May 2, 2022

RE: Proposed Minor Amendments – Walmart Neighborhood Market – 1820 Unser Blvd. NW

0' 10" 20' 30' 40' 50' 60' 70'
GRAPHIC SCALE
1" = 40'
SSM-1

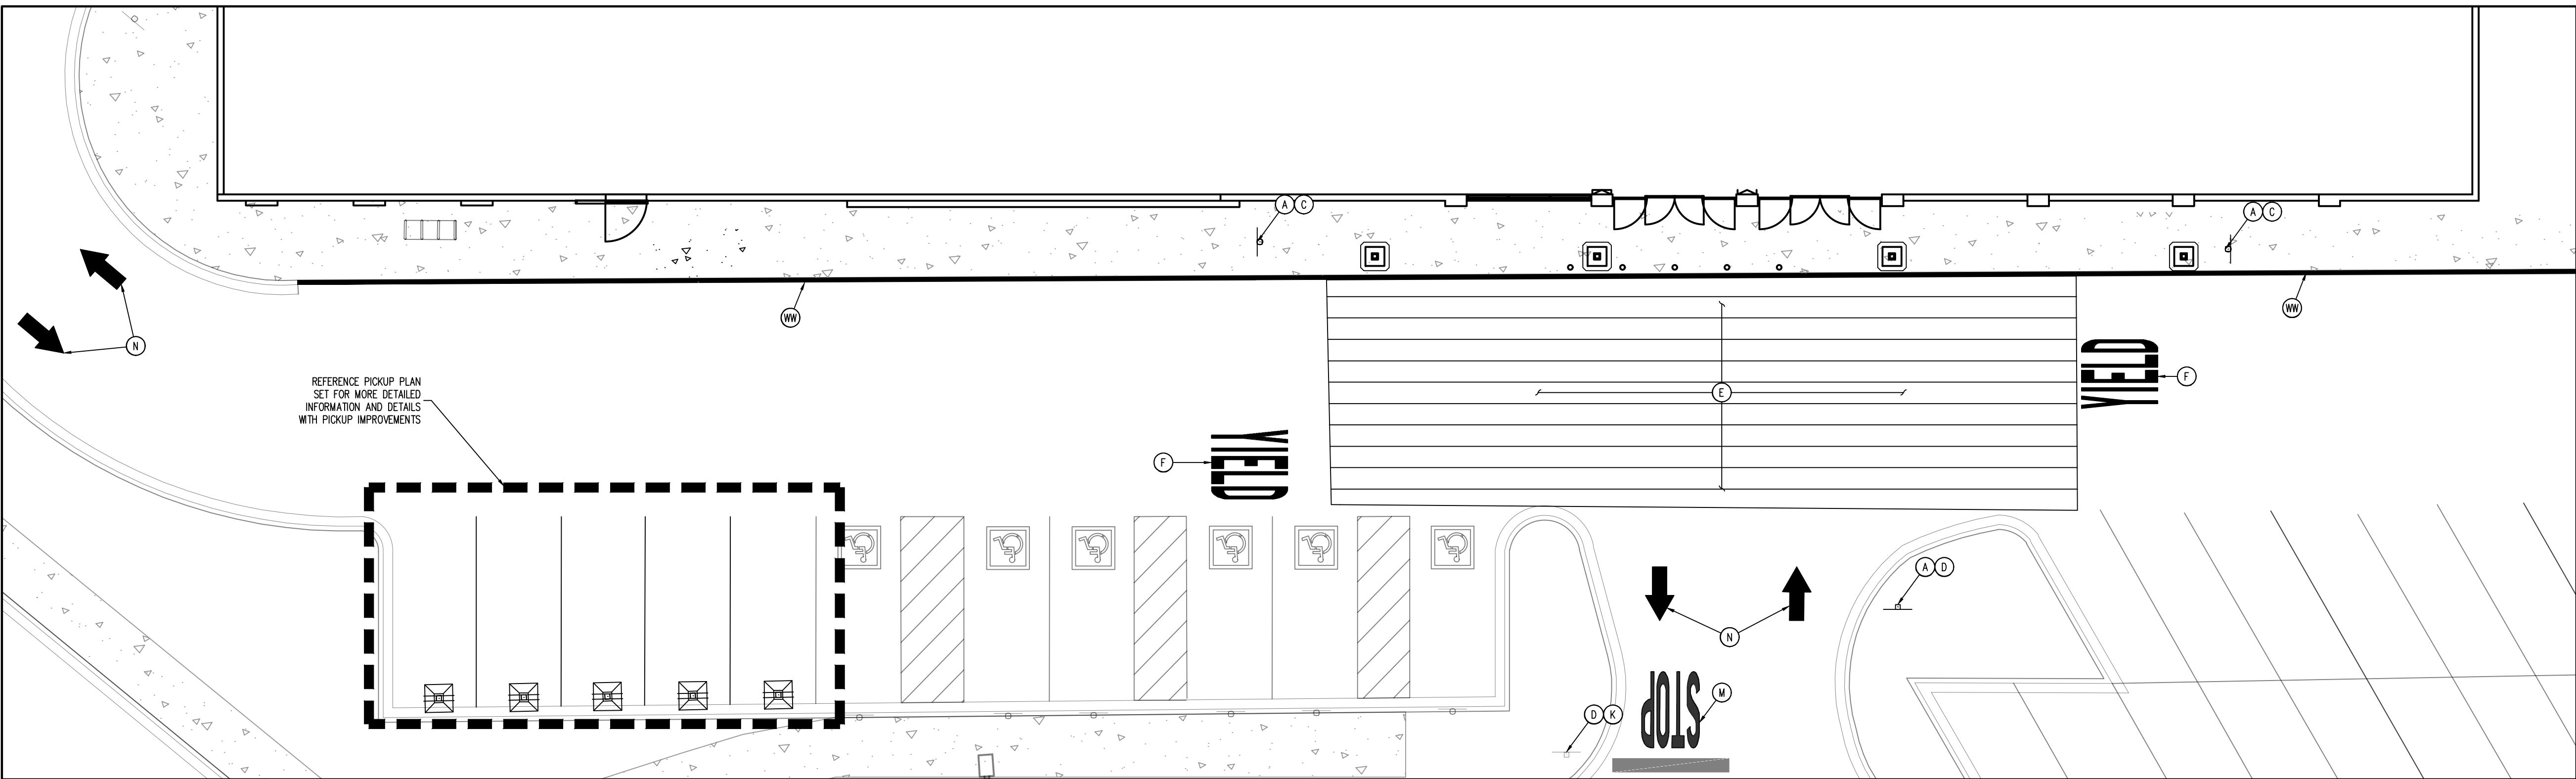
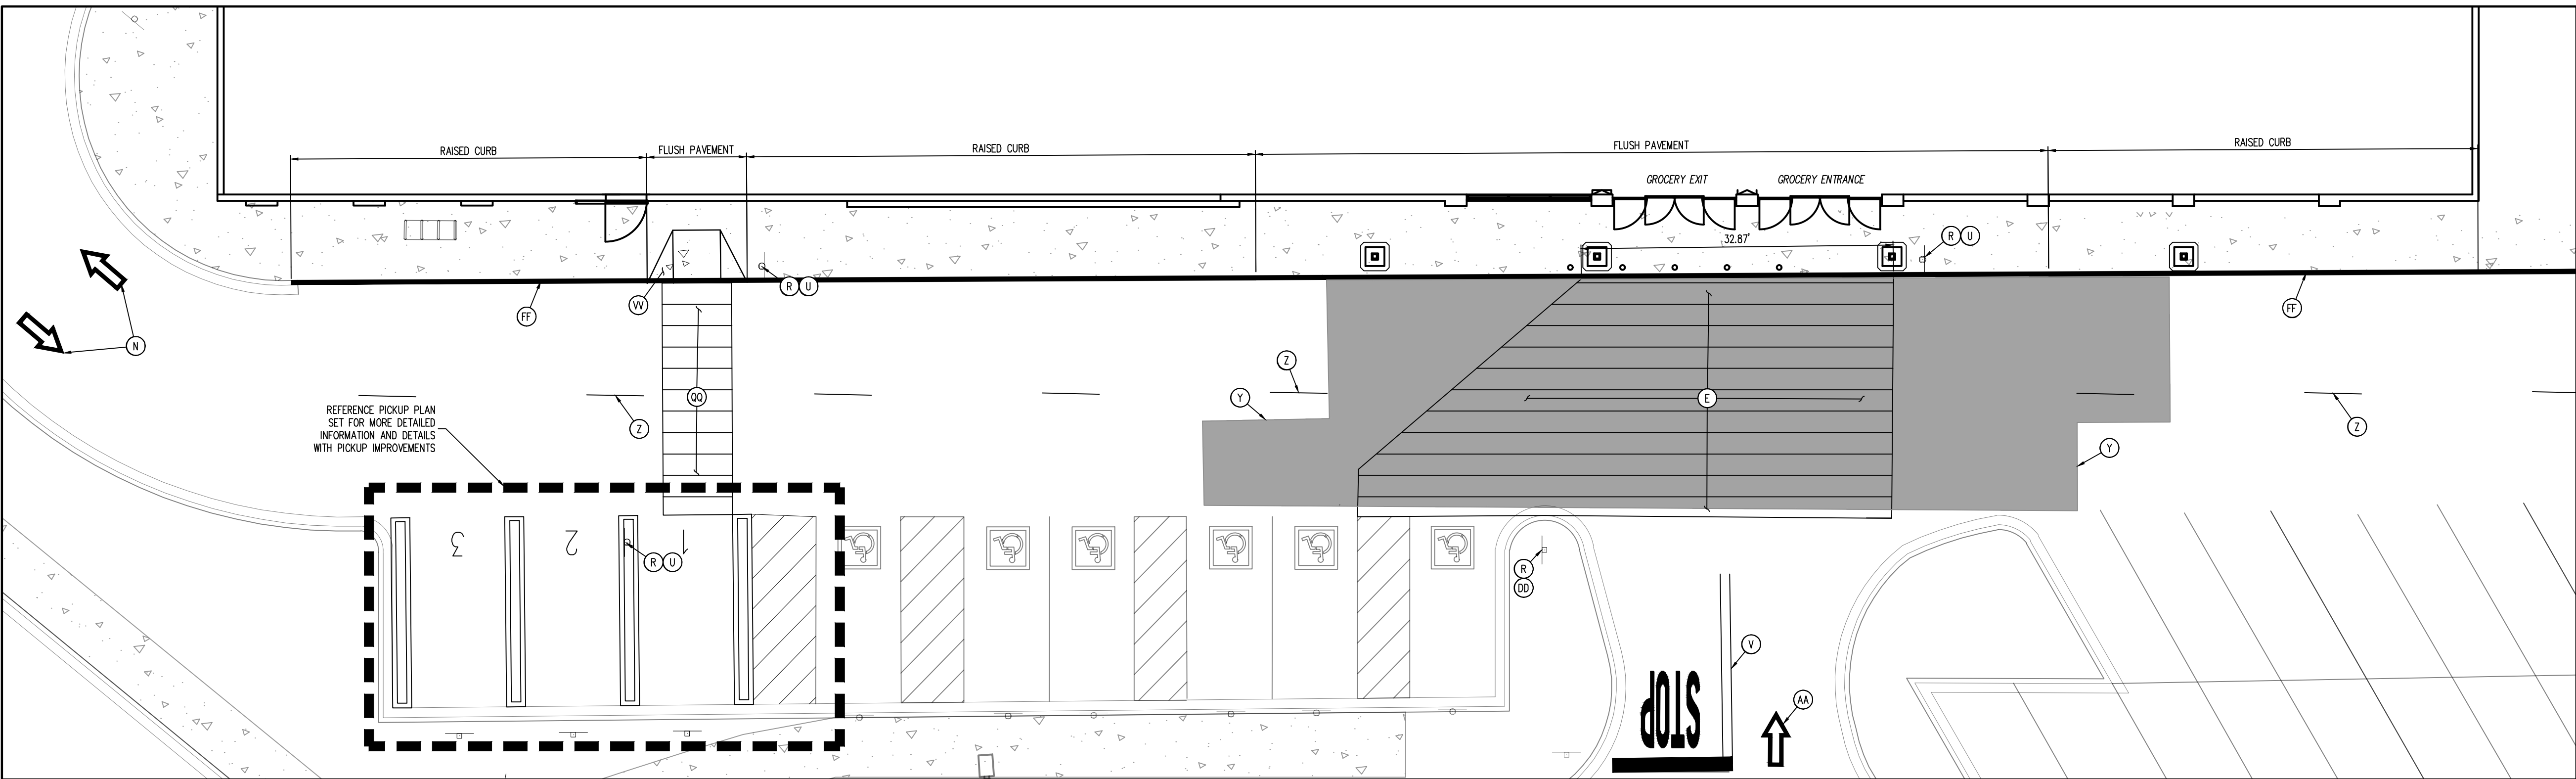
Here's where I run into problems: the PROPOSED site plan, which will get stamped to supersede the Existing site plan, MUST CONTAIN THE EXACT SAME SHEETS. Instead, the proposed site plan only has Sheets A2, A2-1, SSM-1, SECP-1, and SECP-2. Therefore, it's incomplete.

Could you please send, via separate .pdf, a copy of the stamped, existing site plan with the new changes marked on it? The sheets must be the same and the new changes, proposed Spring 2022, need to be clearly shown.
